Response to Applicant's video of drive through of proposed route for construction traffic

Figure 2-5 Indicative Construction Access and Compounds (Rev P01)

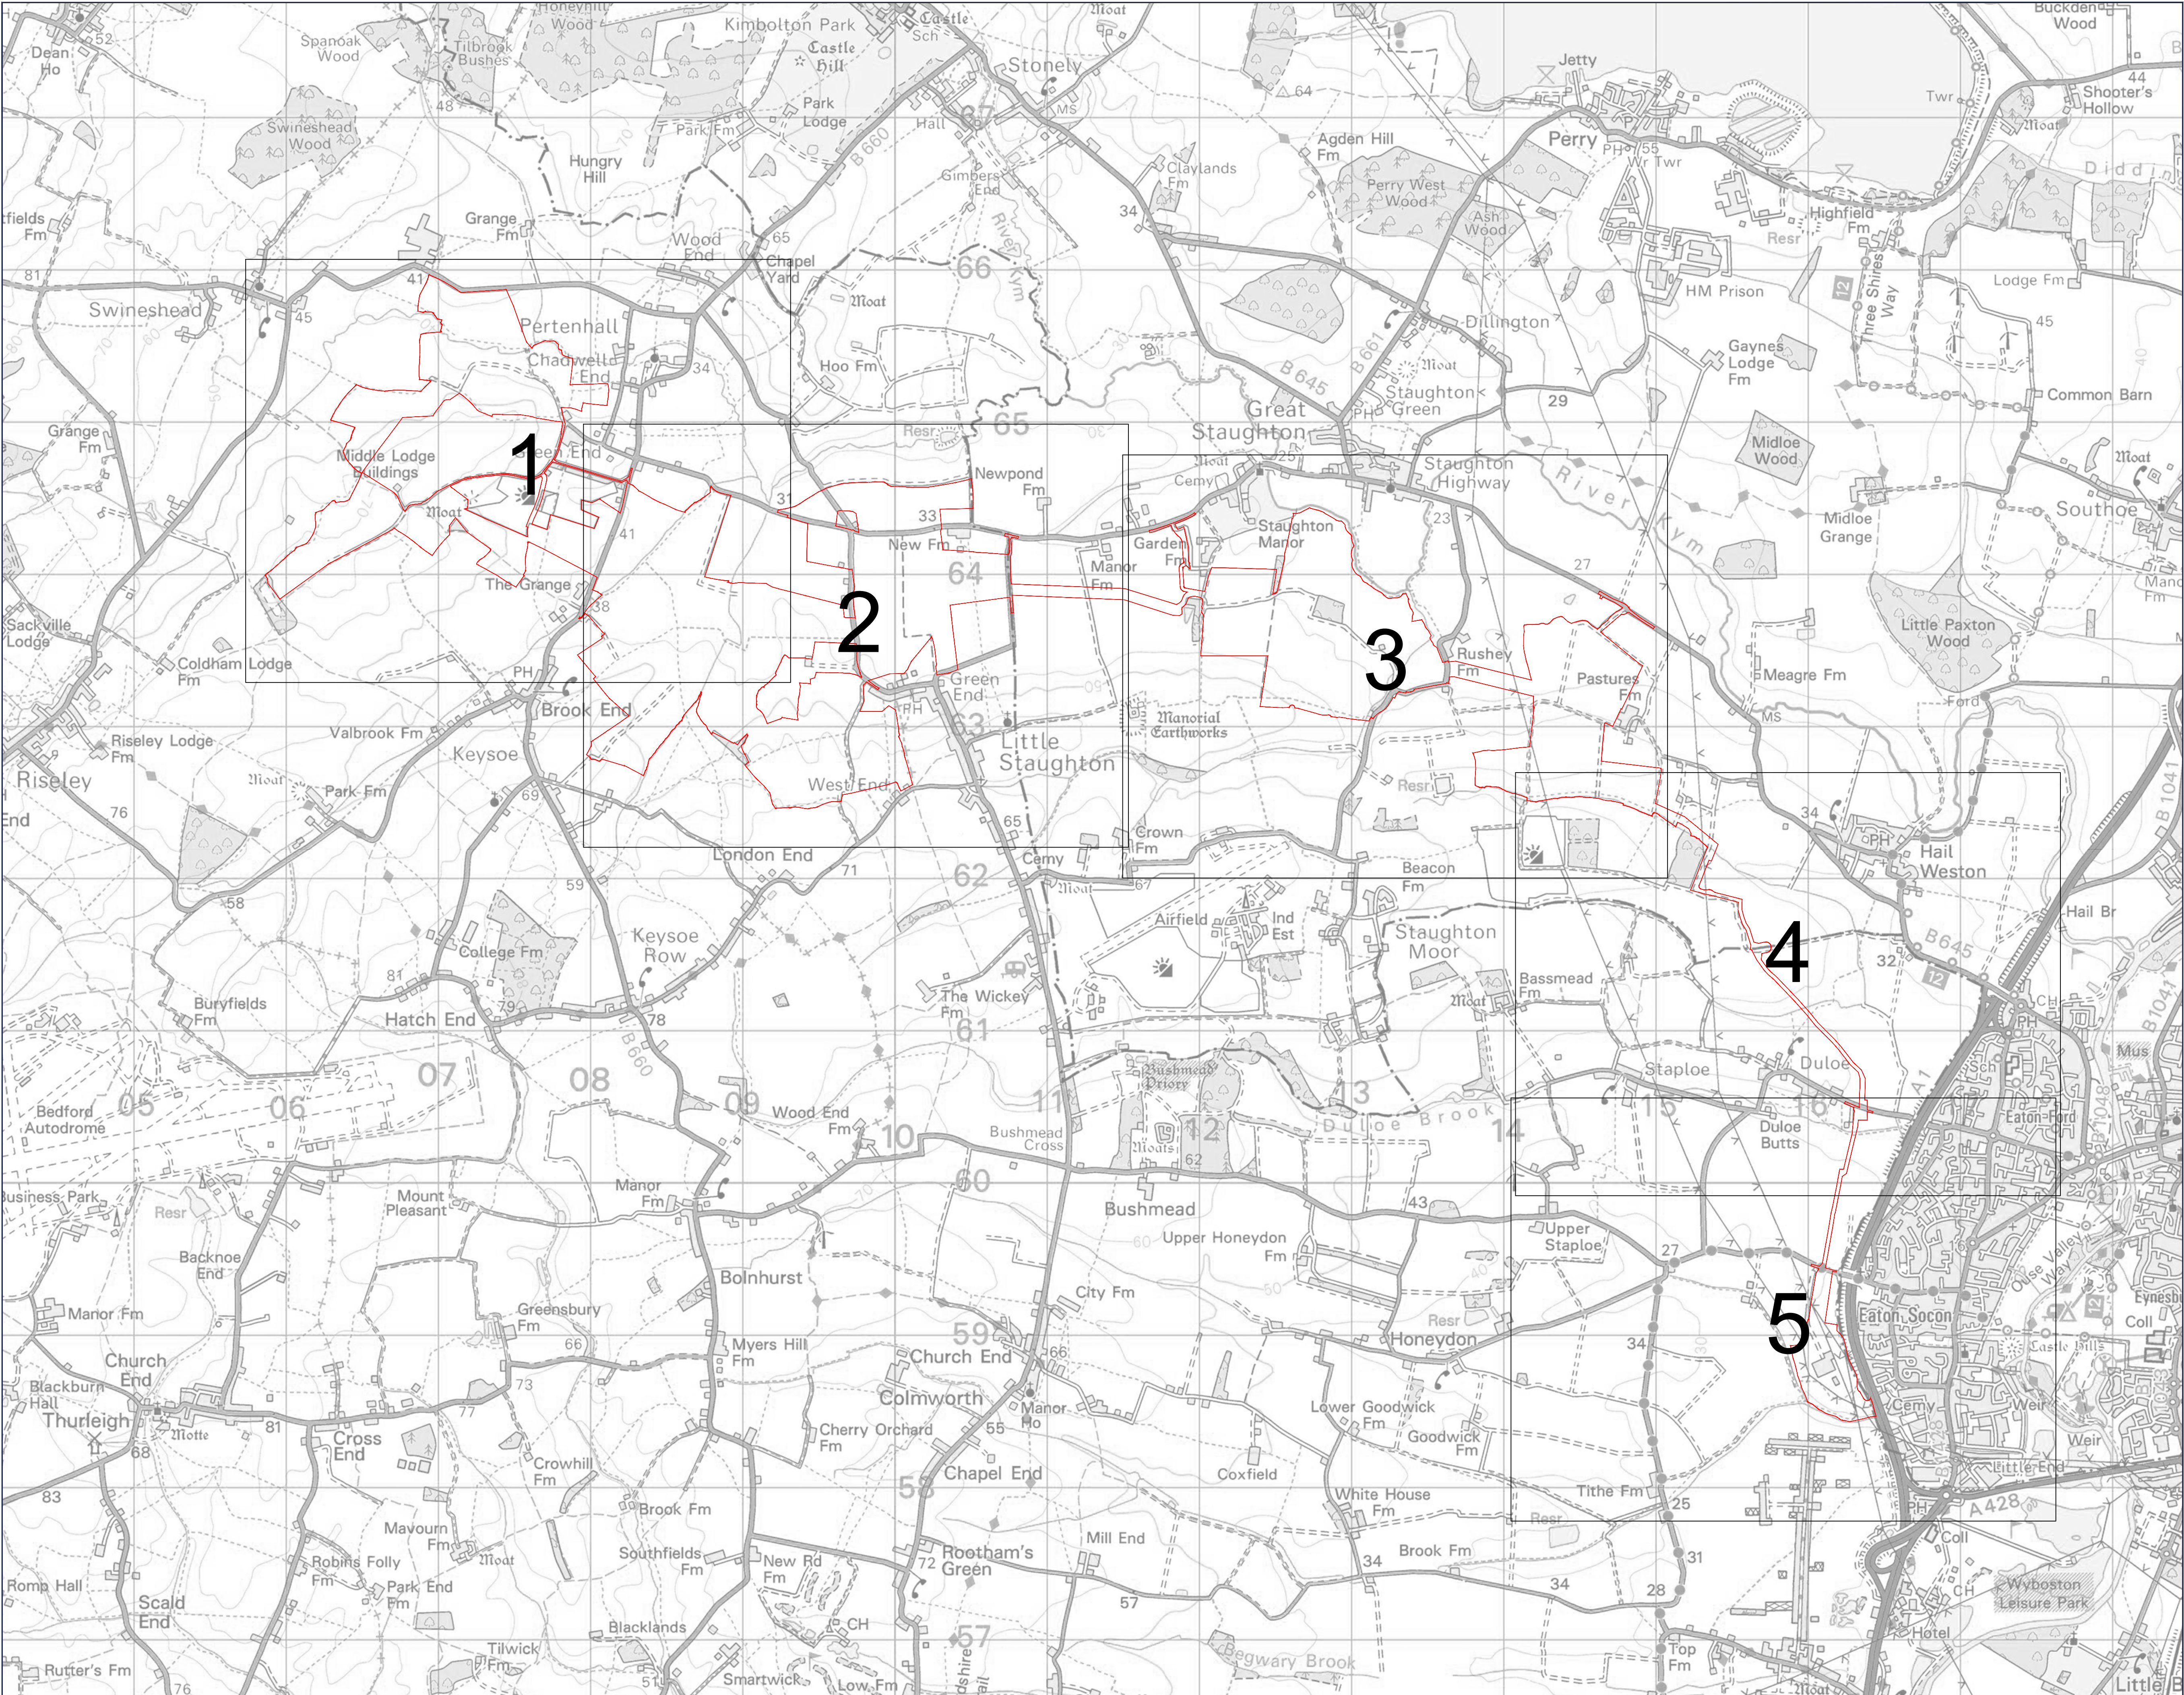
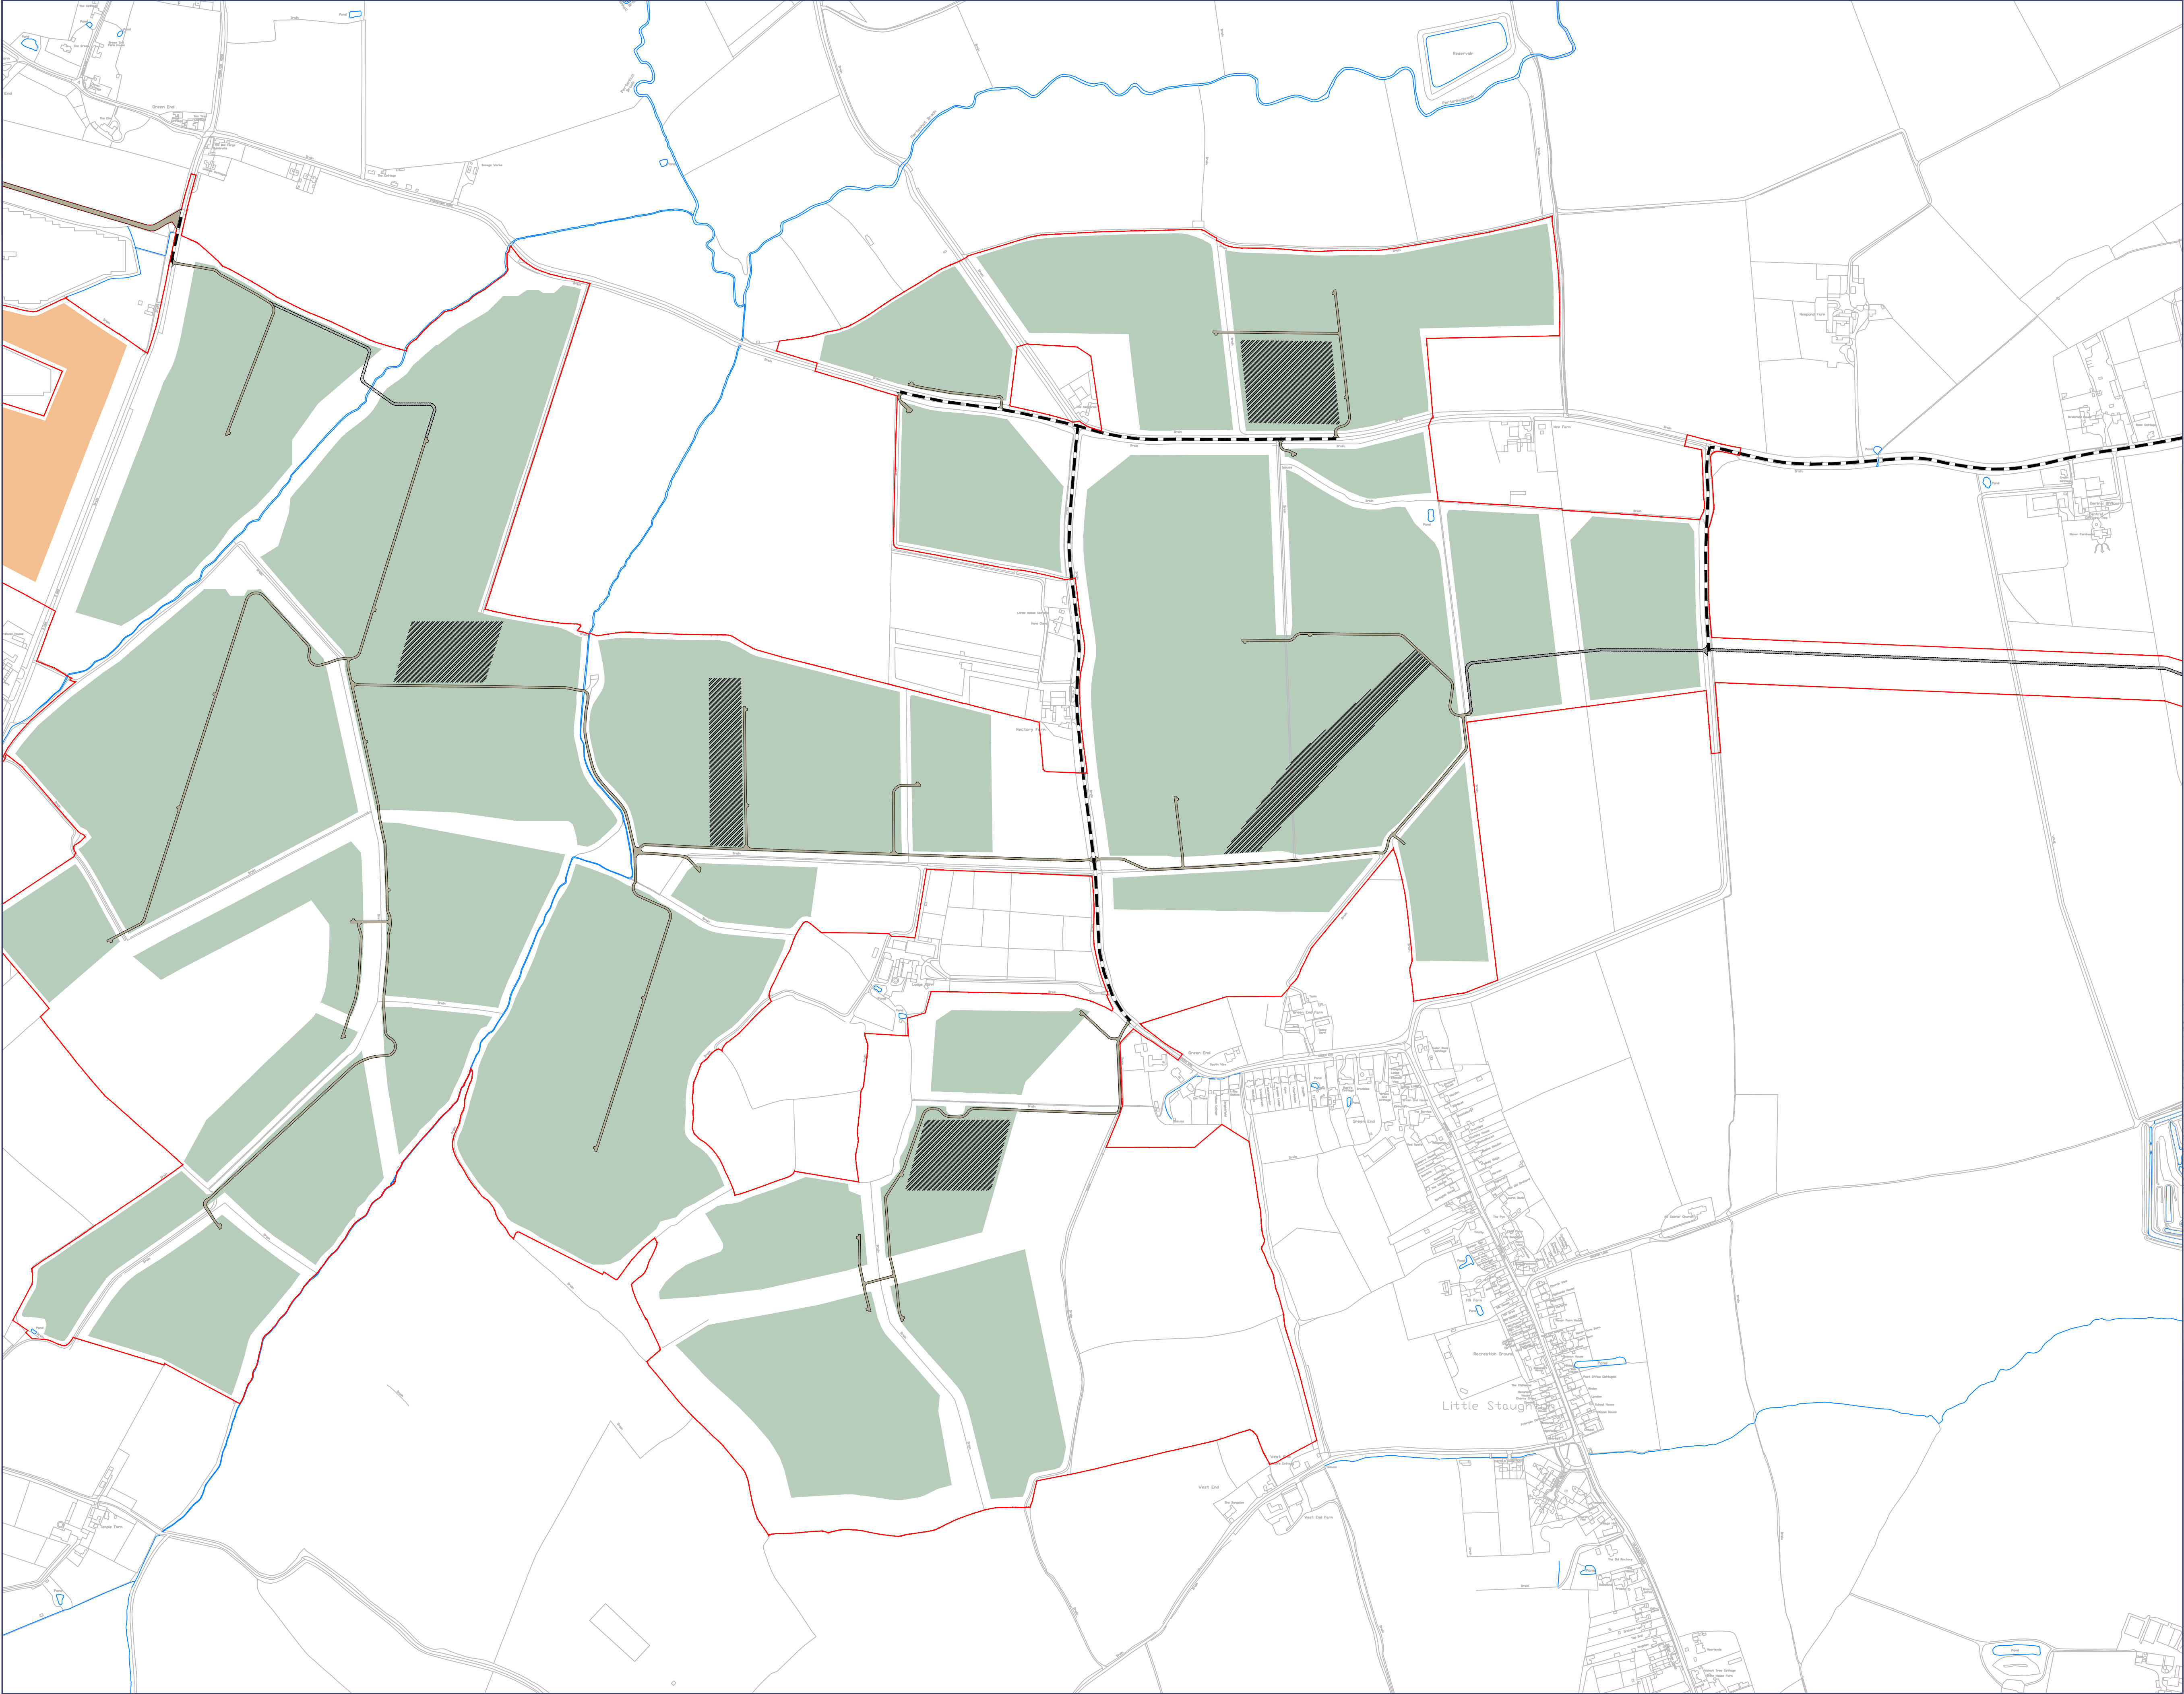
- There is no indication as to the time this video was filmed with reference to traffic volumes at different times of day.
- I was shocked as to the actual mileage and number of local highways being used given the Applicant's claim that constructing a temporary road network across the fields would eliminate disruption to local inhabitants!

- HGVs and workers are only being "encouraged" to use these routes whilst other major infrastructure projects such as EastWest Rail mandate vehicle movements. The routes shown should therefore have included those most likely to be used as alternatives/short cuts by East Park traffic. This would have been a much more honest portrayal of the unsuitability of the local road network which will be impacted by this scheme.
eg the approach through Pertenhall to site A
eg the lanes around the Kangaroo
eg the road access routes to all sites outside the construction phase ie for ongoing operation/maintenance

- Once the temporary construction route has been covered in solar panels all traffic during the operational stage would need to use local lanes so these need to be shown too!
